From: Laura Gibbons
Sent: 18 April 2018 12:42
To: Planning.Responses
Subject: RE: Planning Consultation on: P/25/18/PL

Engineers comments with respect to drainage:

Site Address: Jenin Nyetimber Lane Pagham PO21 3JT

Description of Works: Demolition of existing garage, roof alterations to existing dwelling to provide first floor & 1 No. new dwelling in garden of existing dwelling.

Job Title		Jenin, Nye/timber Lane Bognor Regis PO21 3JT			
Drawing Title	Block Plan Proposed				
Client	R B				
Date	12/05/2017				
Drawn	P.J.G				
Scale	1:500 on A3				
Dwg No.	NT/L/BP/02				B

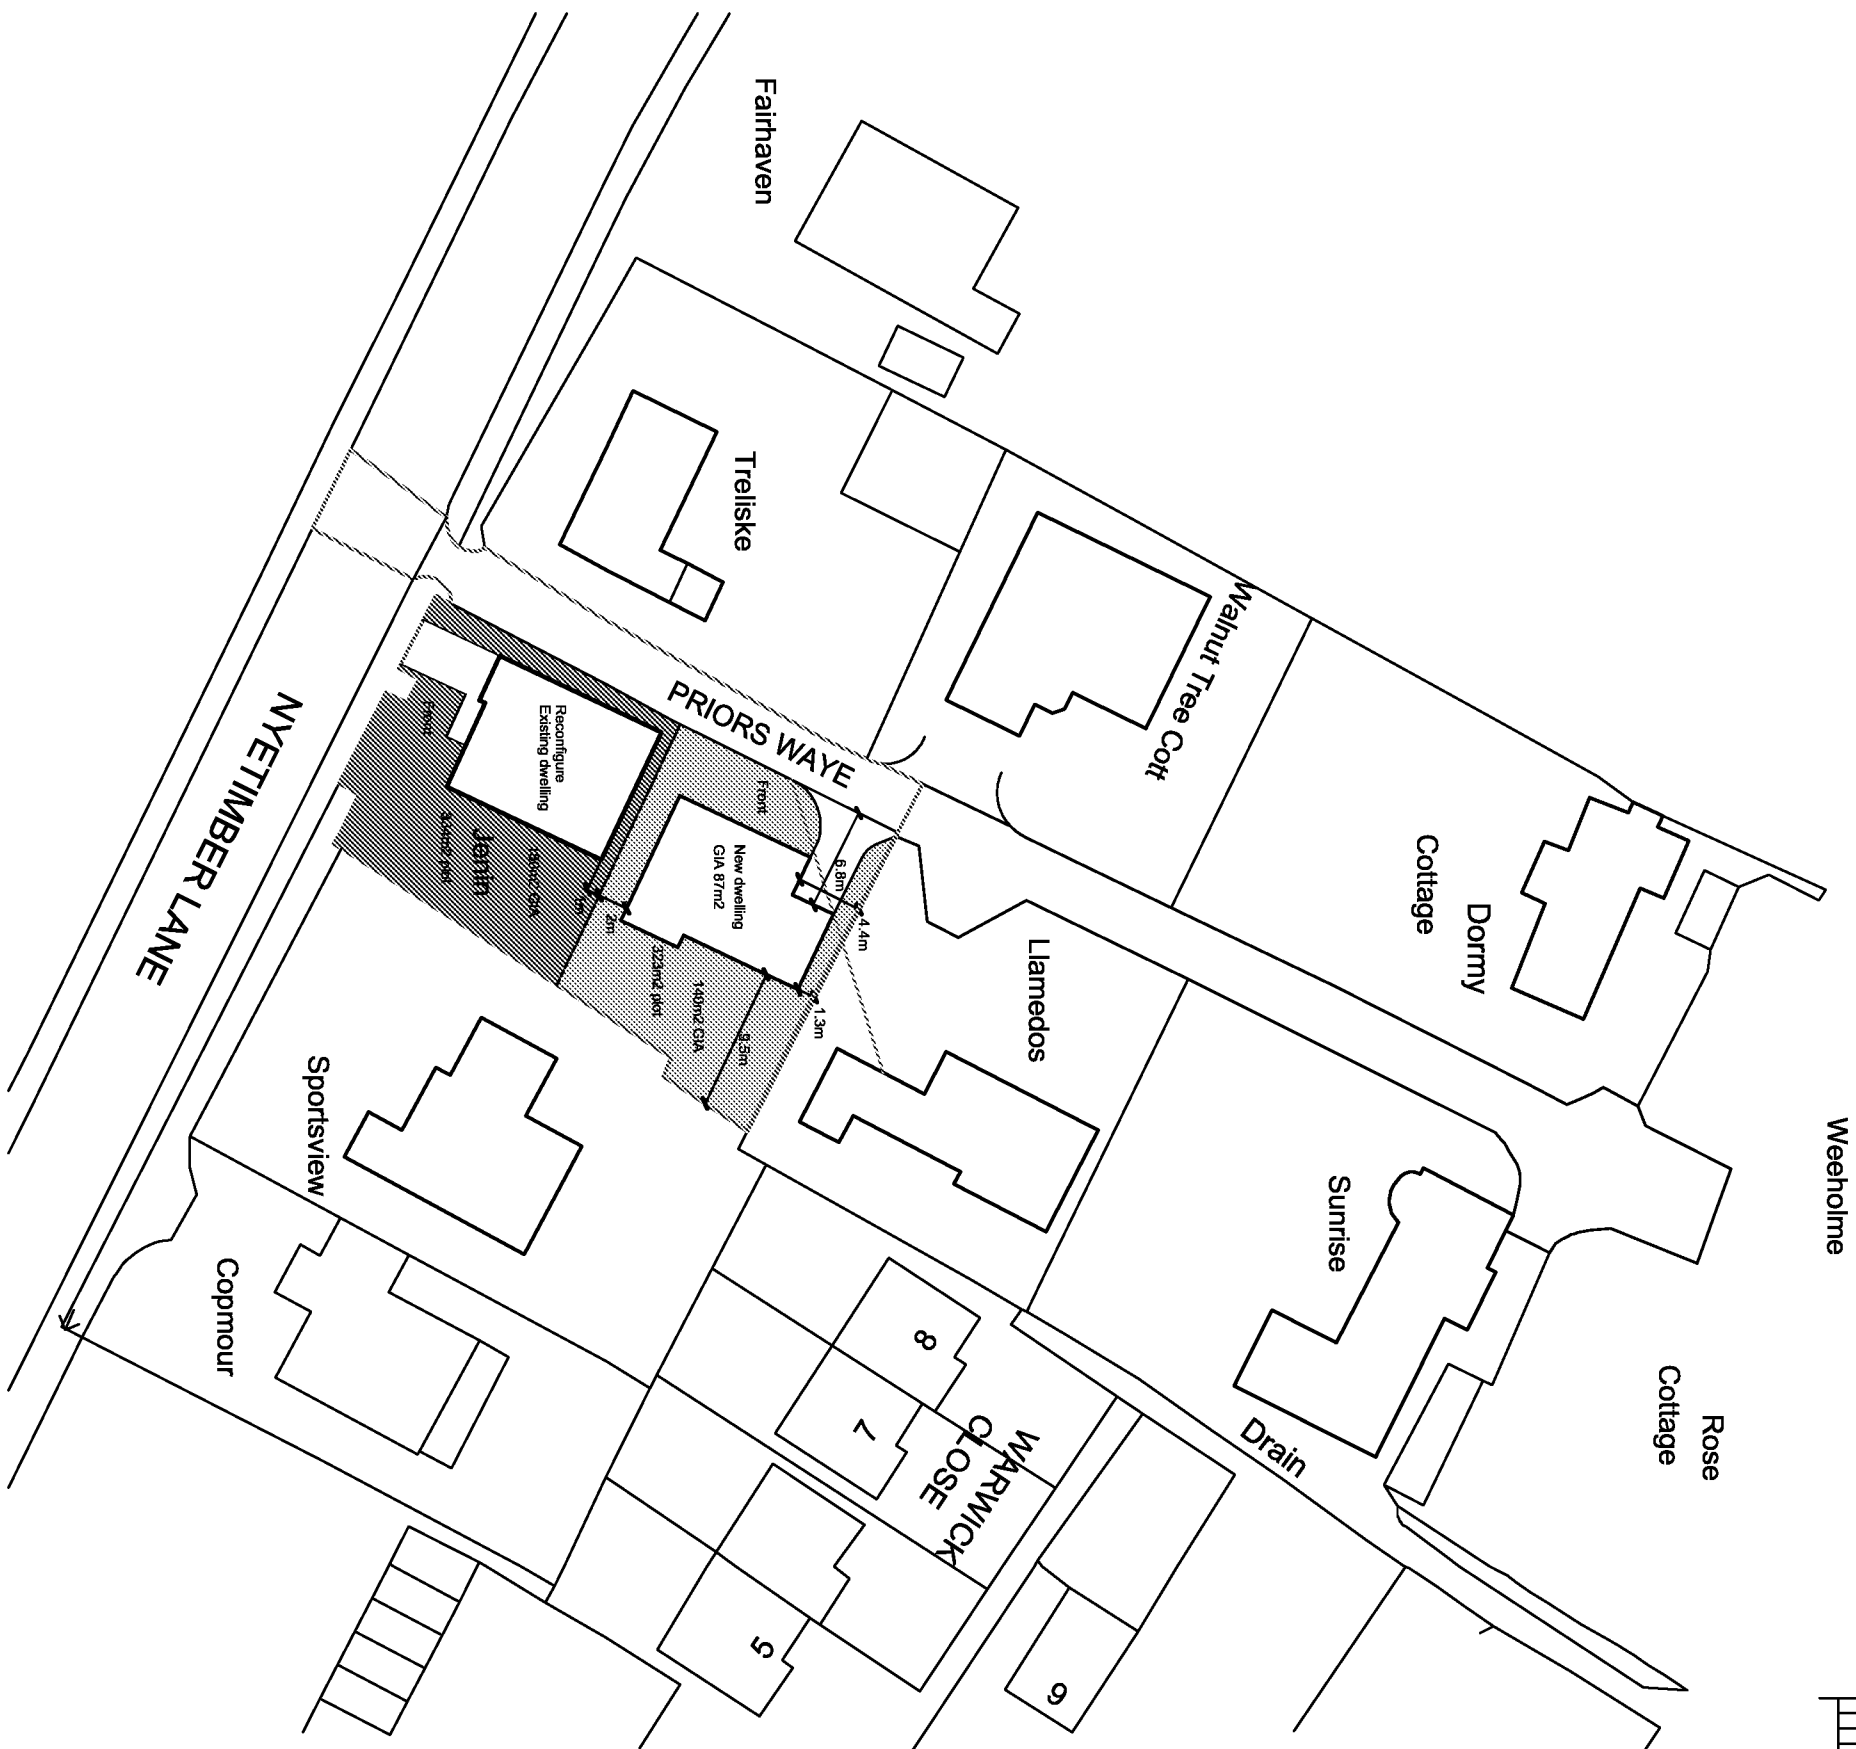
There may be a culverted watercourse running along the eastern boundary of the site. It is advised that the applicant gets in contact with us to discuss this.

A Southern Water sewer crosses the proposed site. Therefore, early engagement with Southern Water is advised.

The development must not cause any detriment to culverted or open watercourses. Any proposals to alter or culvert this will require ordinary watercourse consent. And a minimum of 3m easement to watercourses will be required to enable future maintenance of the watercourse.
